Re: Planning Application No. CM/10/18/OUT - (Case Officer Mr J Baeza)

Outline planning permission erection of 1 No. 4-bed detached bungalow, 2 No. 3-bed detached chalet bungalows & 2 No. 3-bed semi-detached bungalows & associated works. Departure from the Development plan of the site Mistletoe Farm, Horsemere Green Lane, Climping.

title  
**VISIBILITY SPLAYS AT ACCESS**

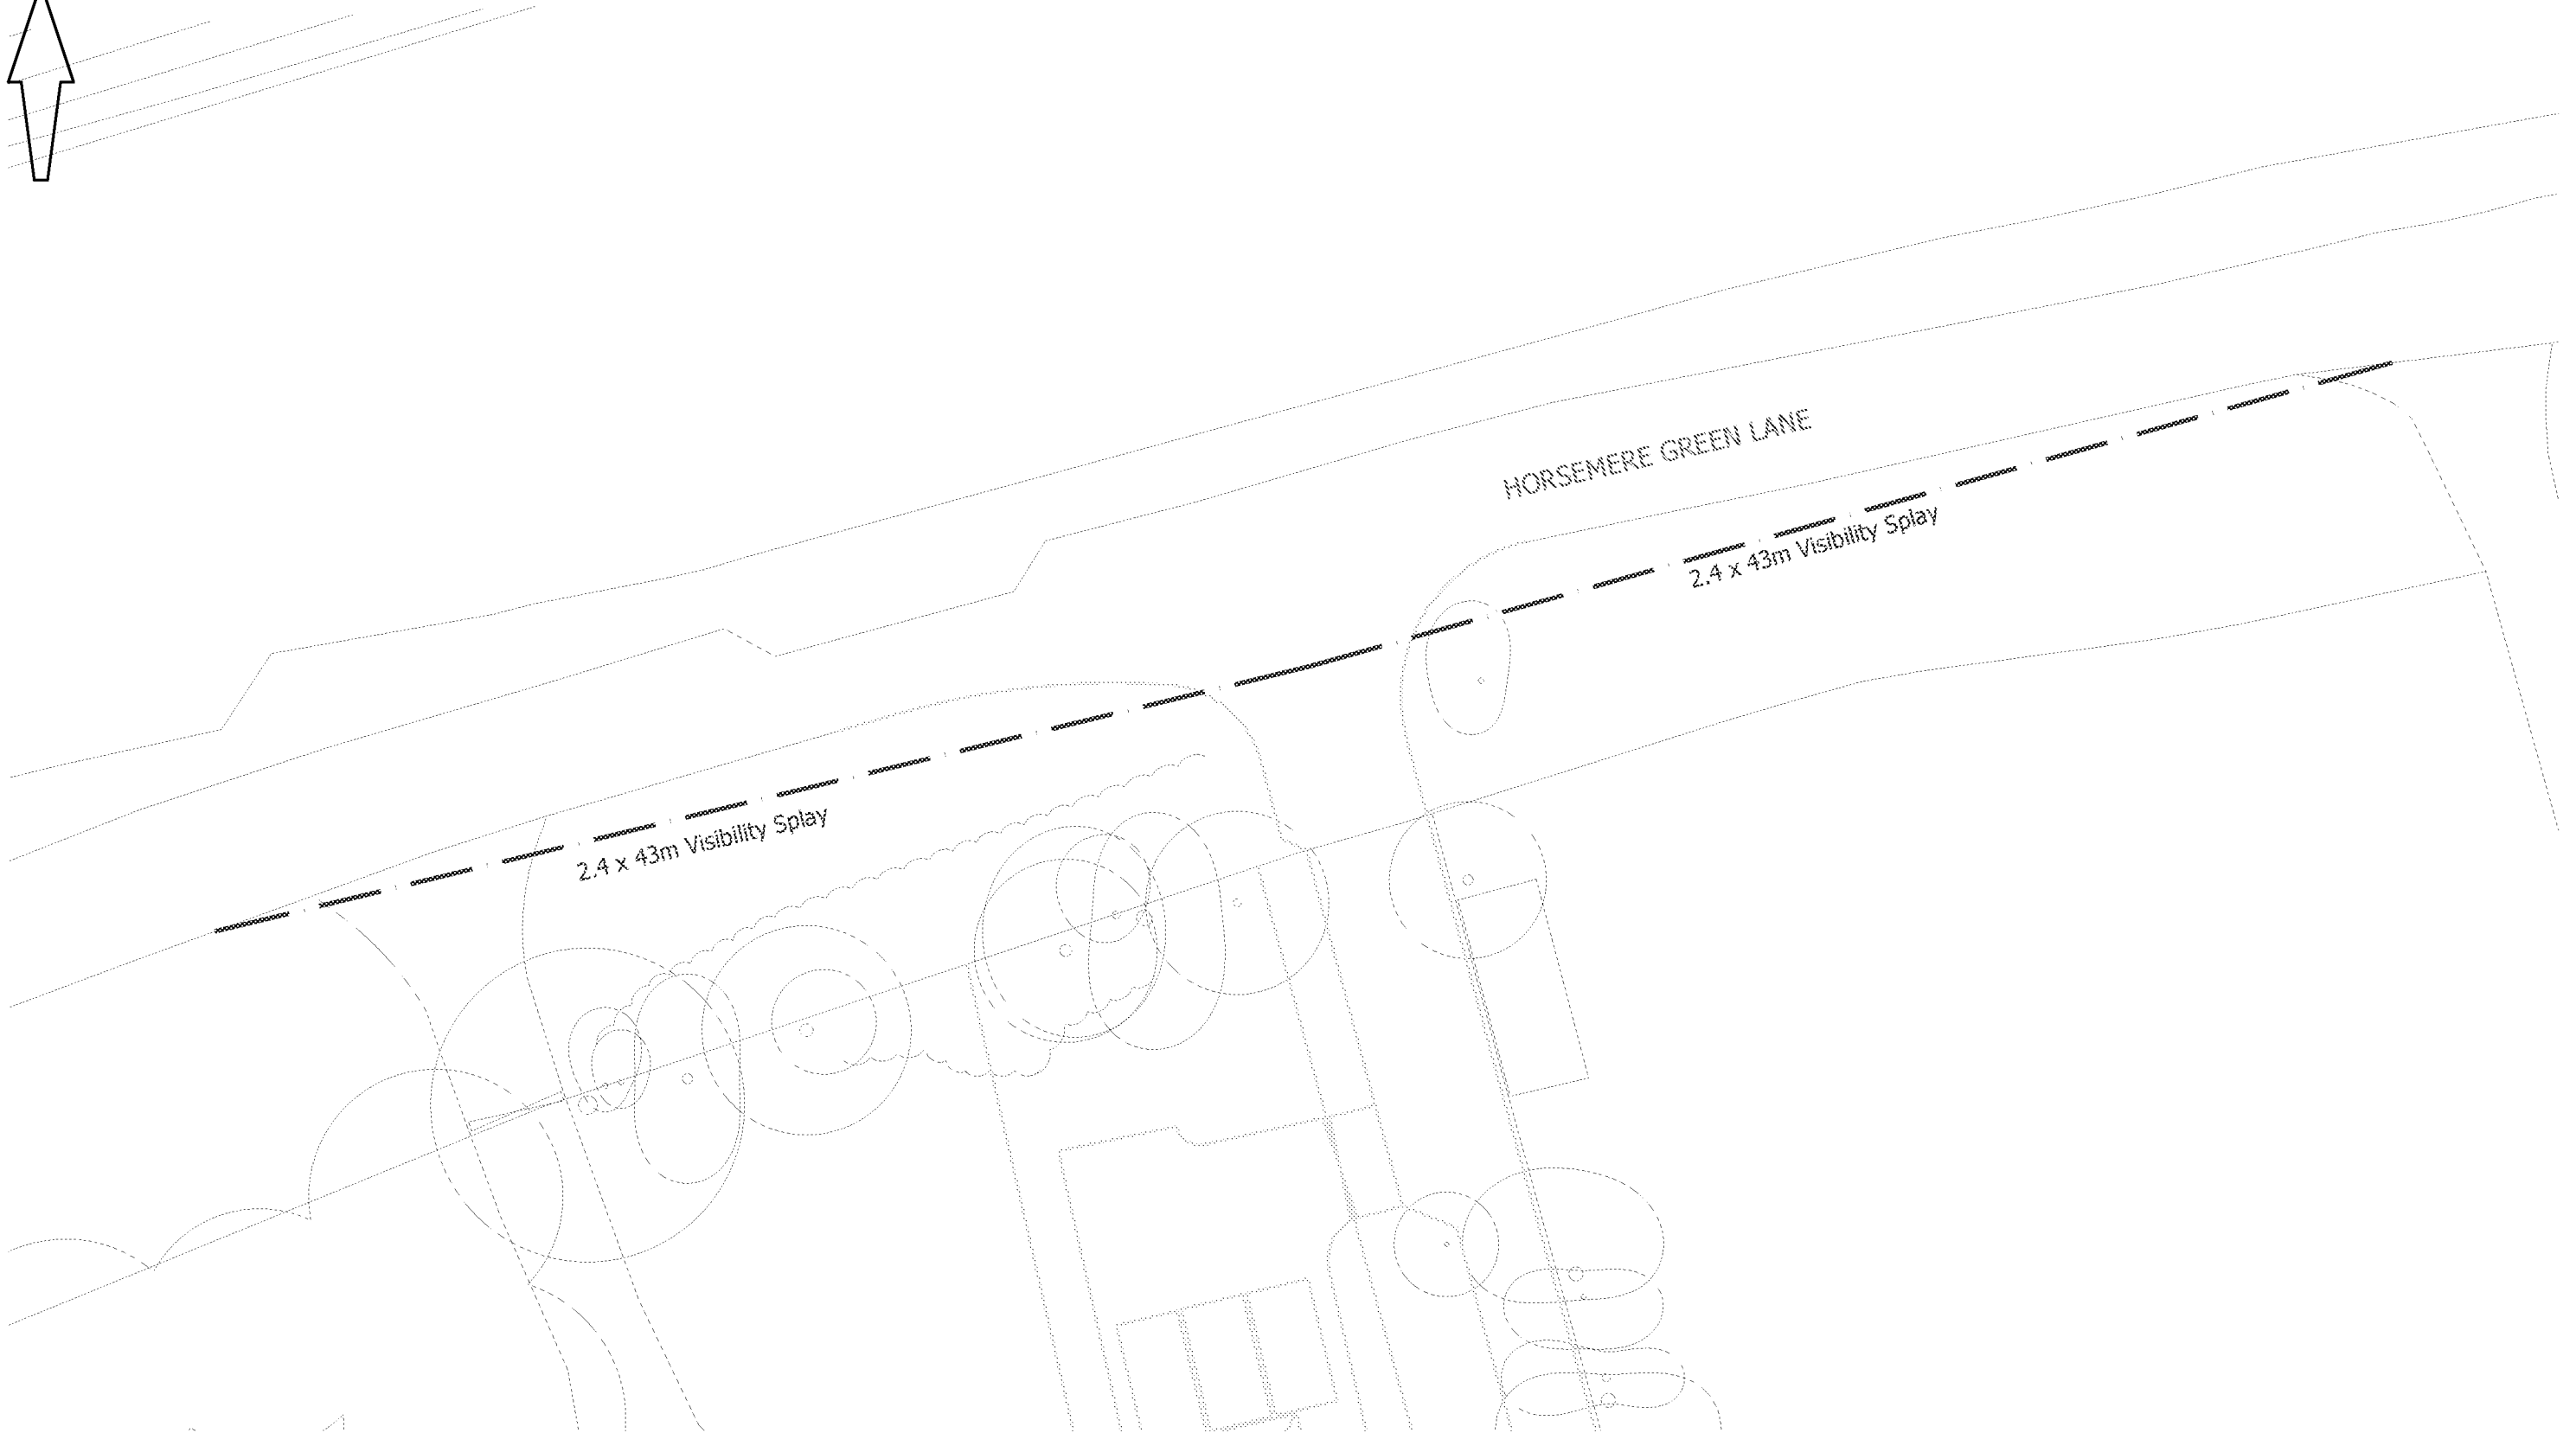
The proposed site access road at Mistletoe Farm would restrict a view on exiting a right-turn from Wooldridge Walk or a left-turn from Appletree Close into Horsemere Green Lane. The location of a 'traffic calming island' (see photos enclosed) is situated opposite the proposed site access. Construction traffic will be restricted in making safe manoeuvres when entering and leaving the proposed site compromising highway safety forcing pedestrians/cyclists into the road - an accident waiting to happen!
